Recommendation Report for Planning Permission for Works or Extension to a Dwelling

REF NO: M/128/21/HH

LOCATION: 2 Elmer Court
Elmer
Middleton-On-Sea
PO22 6JT

PROPOSAL: Installation of 1 x front dormer.

Elevations-Right/Left side

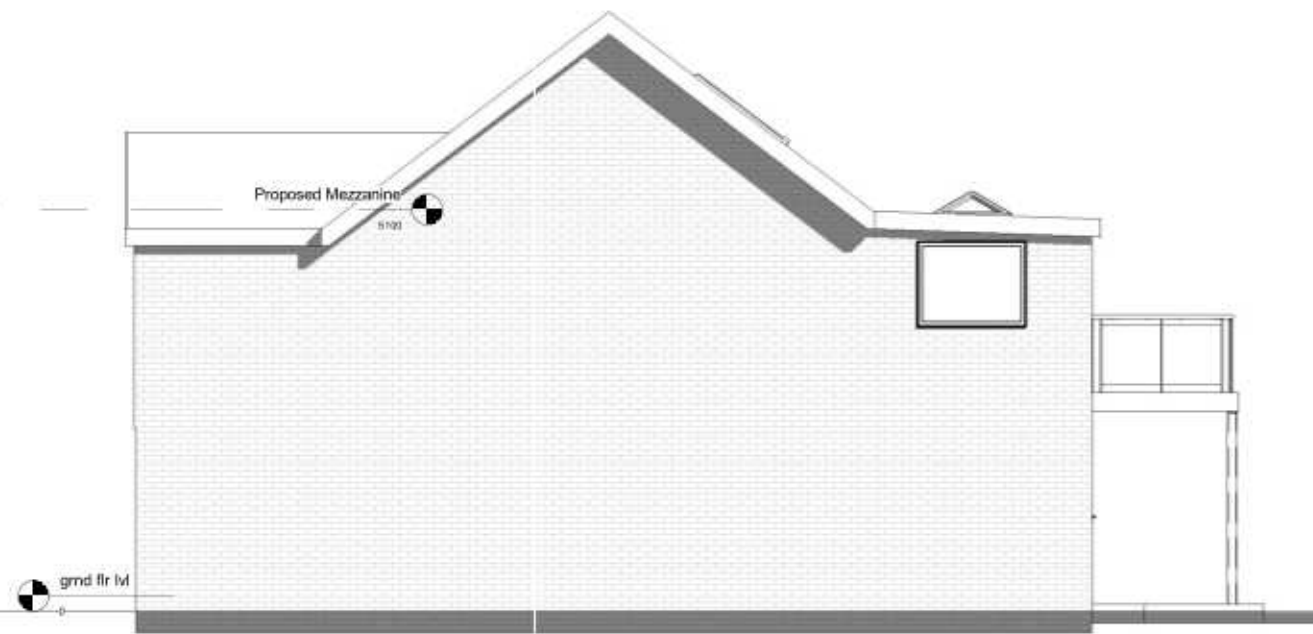
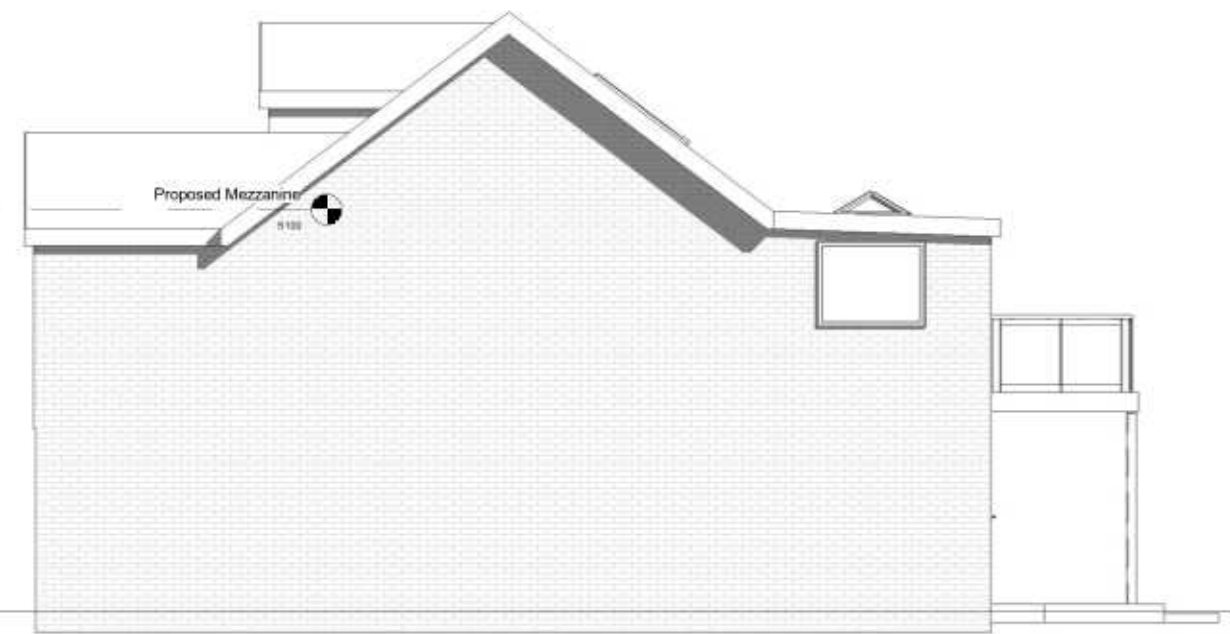
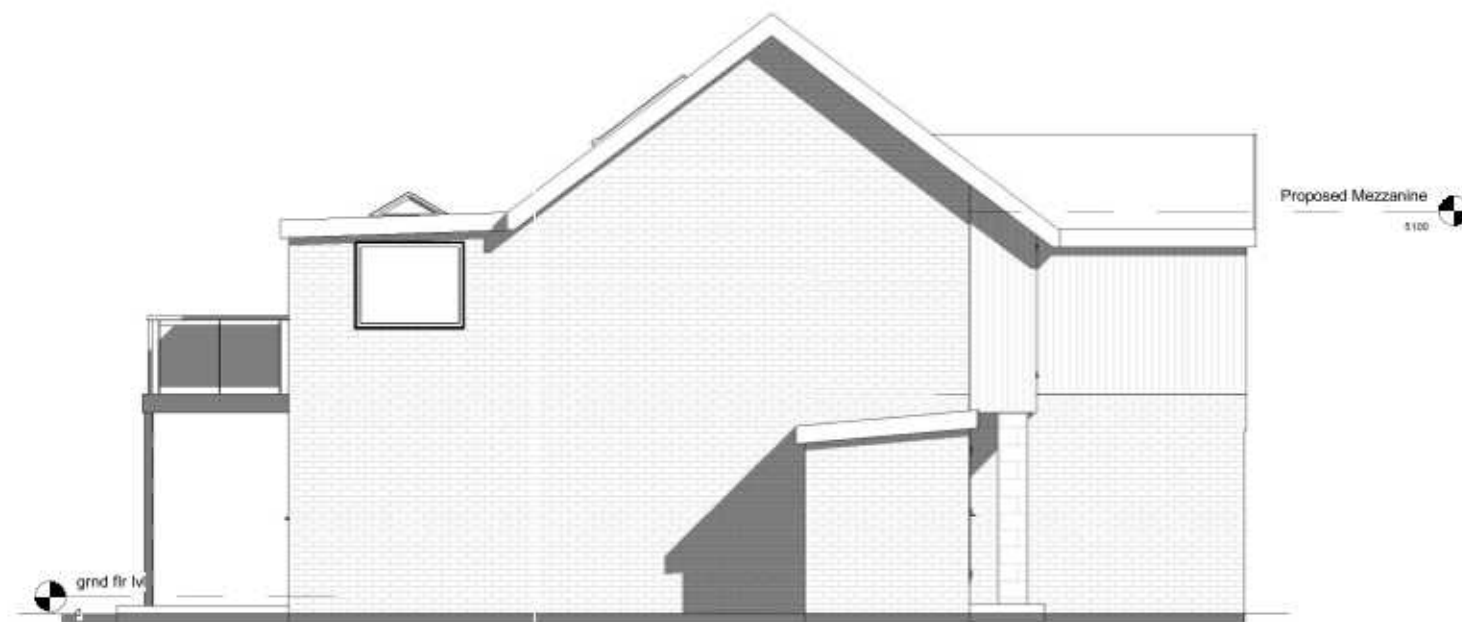
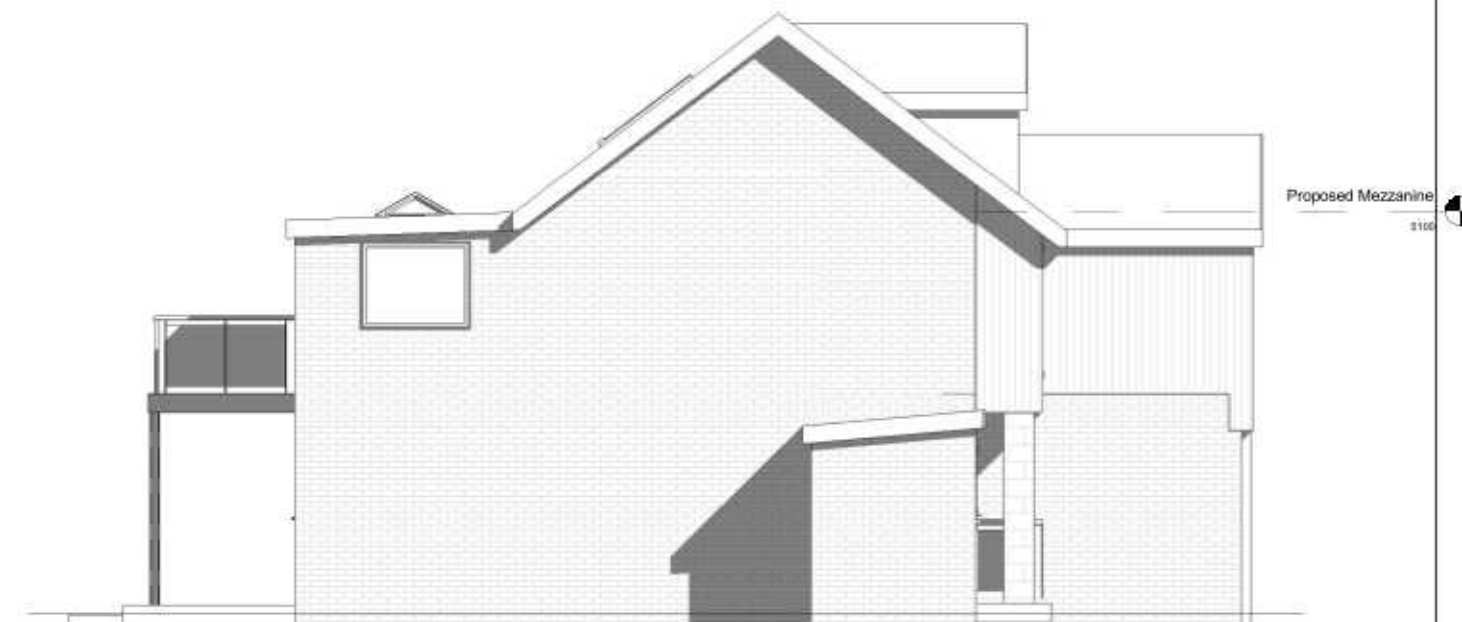
The dormer extension is less than a third of the width of the roof and 2/3 of the depth of the roof making it unobtrusive in the street scene as well as well integrated and subservient to the host dwelling in accordance with policy D DM4 of the Arun Local Plan.

Materials which closely match the facing roof tiles of the existing house will assist with ensuring the proposal appears integrated with the development on site.

Reason: For the avoidance of doubt and in the interests of amenity and the environment in accordance with policy D DM1 of the Arun Local Plan.
- 3 The materials and finishes of the external walls and roof of the dormer hereby permitted shall match in colour and texture those of the existing building.
